WOODMEN HILLS METROPOLITAN DISTRICT
LIFT STATION #1 REPLACEMENT
LANDSCAPING PLAN & NOTES

100% DESIGN DRAWINGS

Project No.: 112.96
Date: 08/21/18
Design: RMM
Drawn: RMM
Check: DES

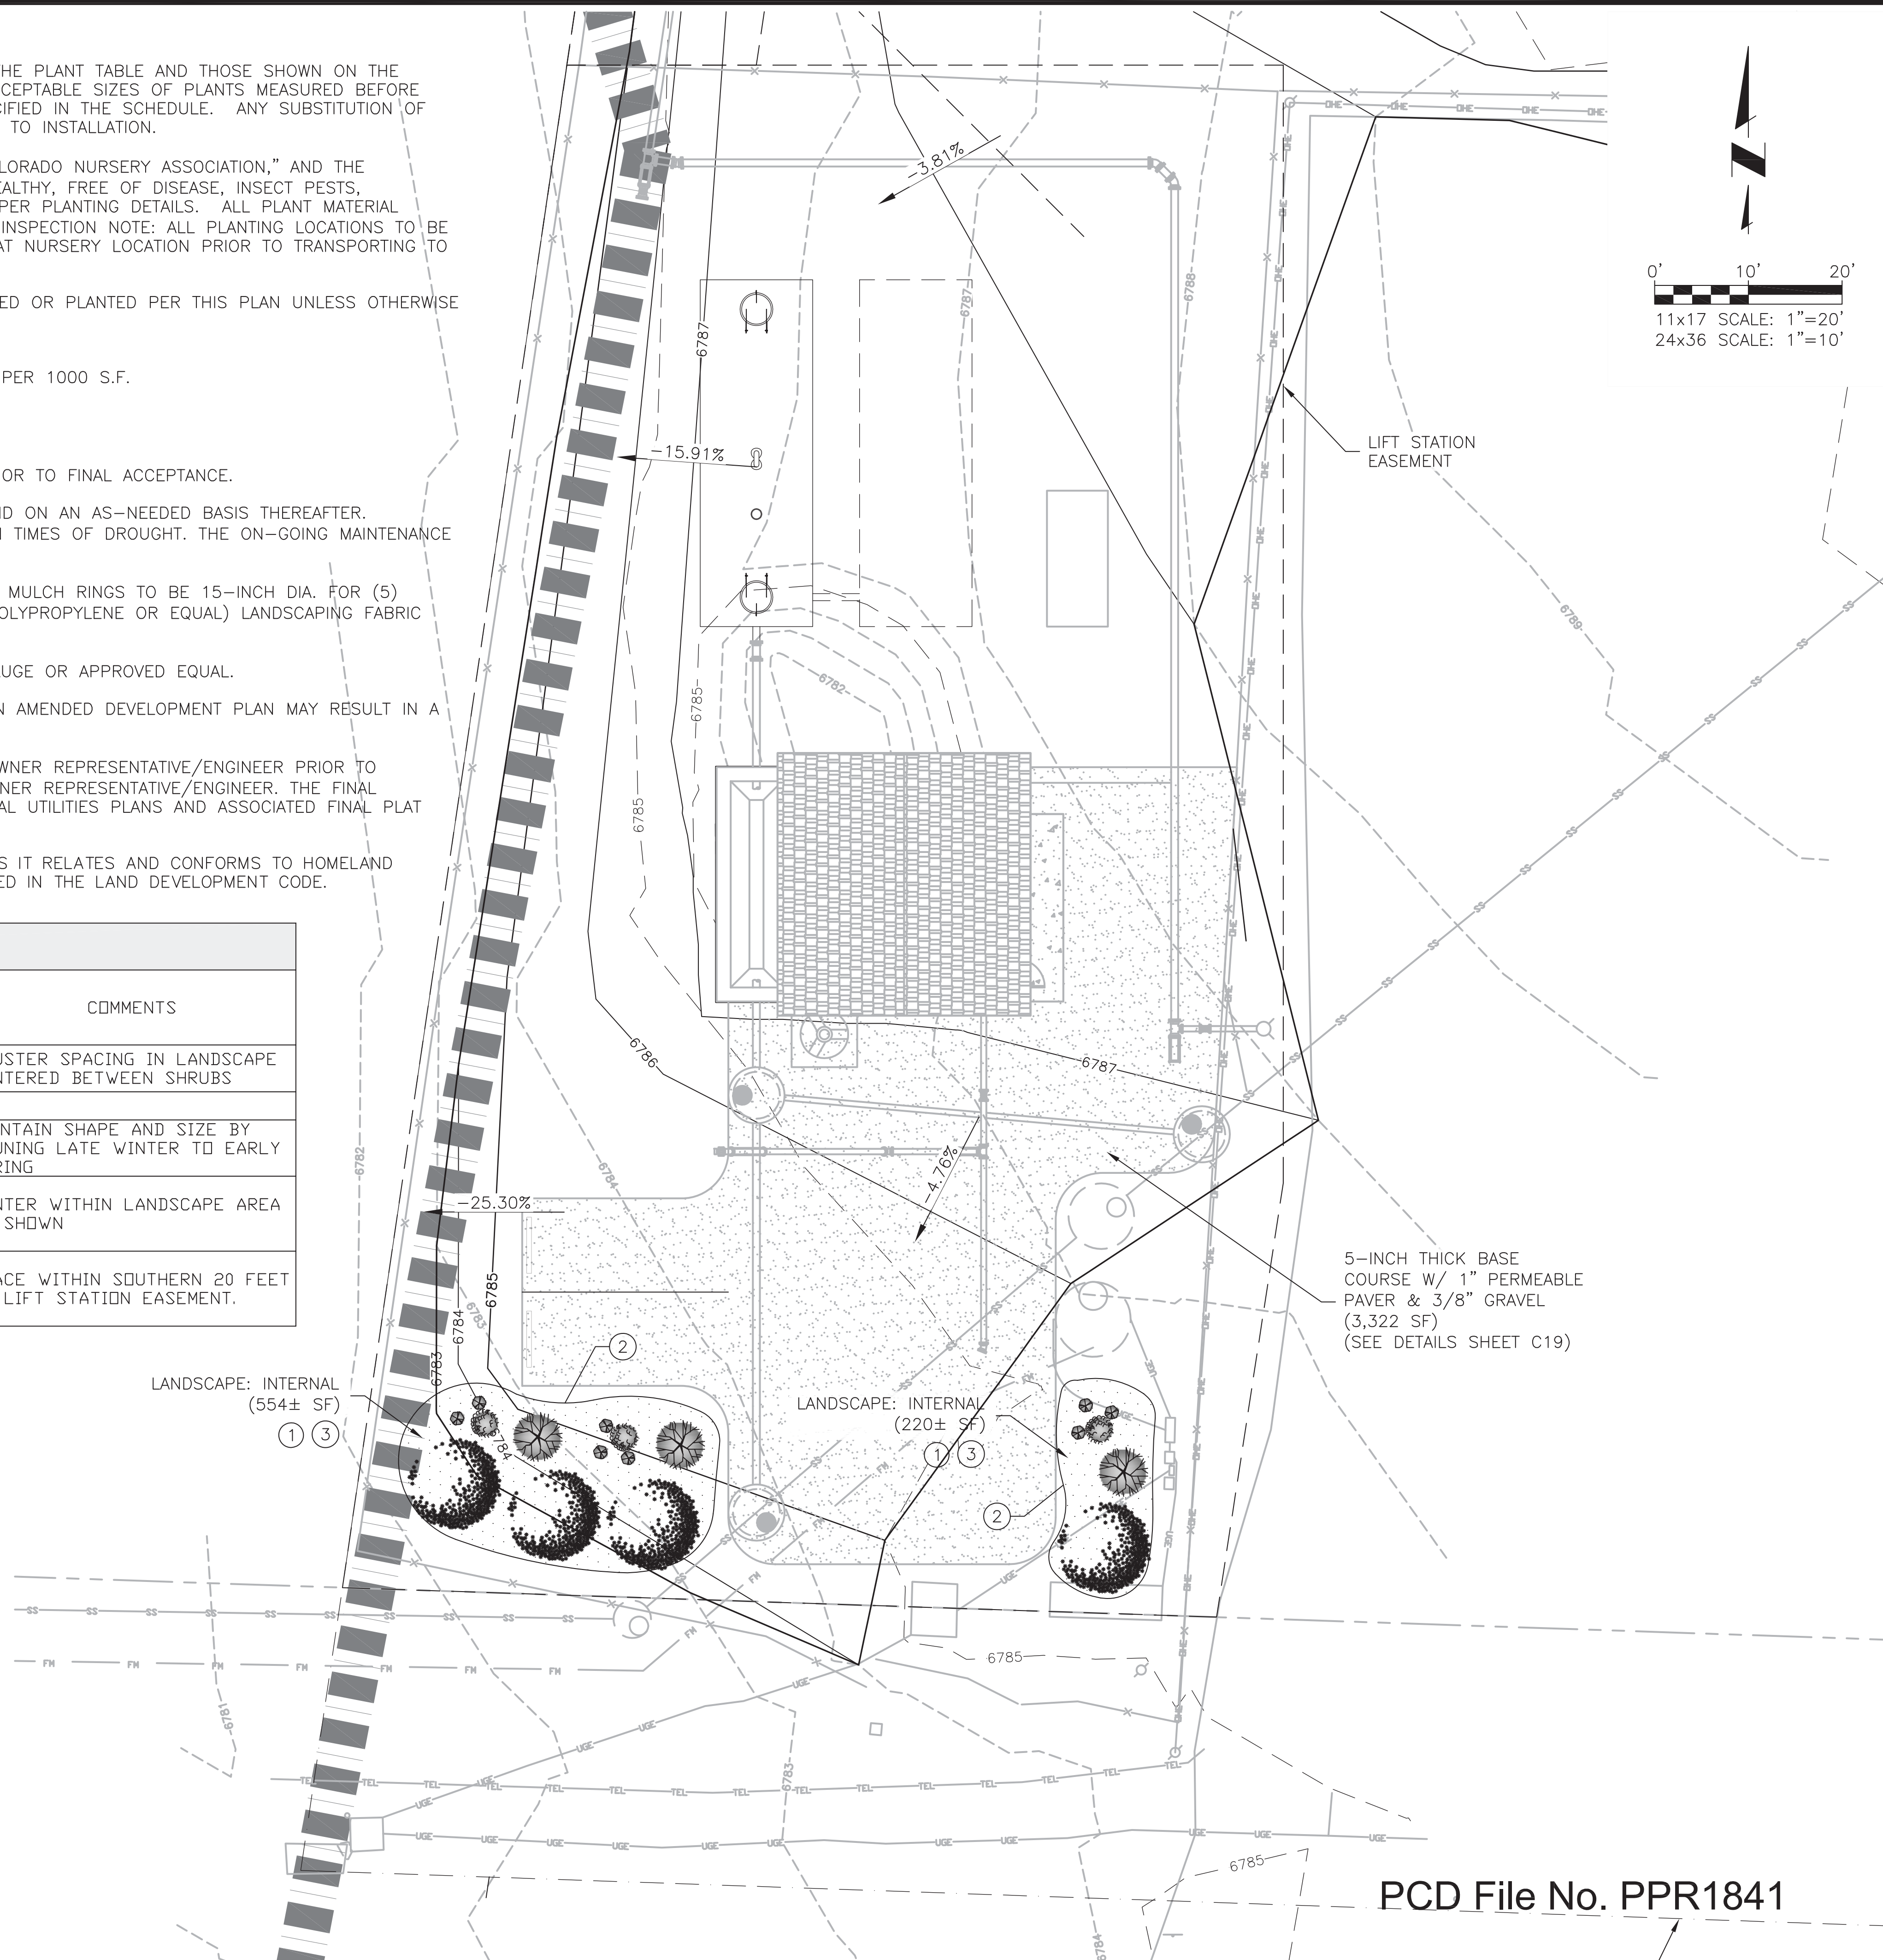
Falcon Highway is considered a Minor Arterial and would require roadway landscaping with a 20 foot depth with 1 tree per 25 feet of frontage.
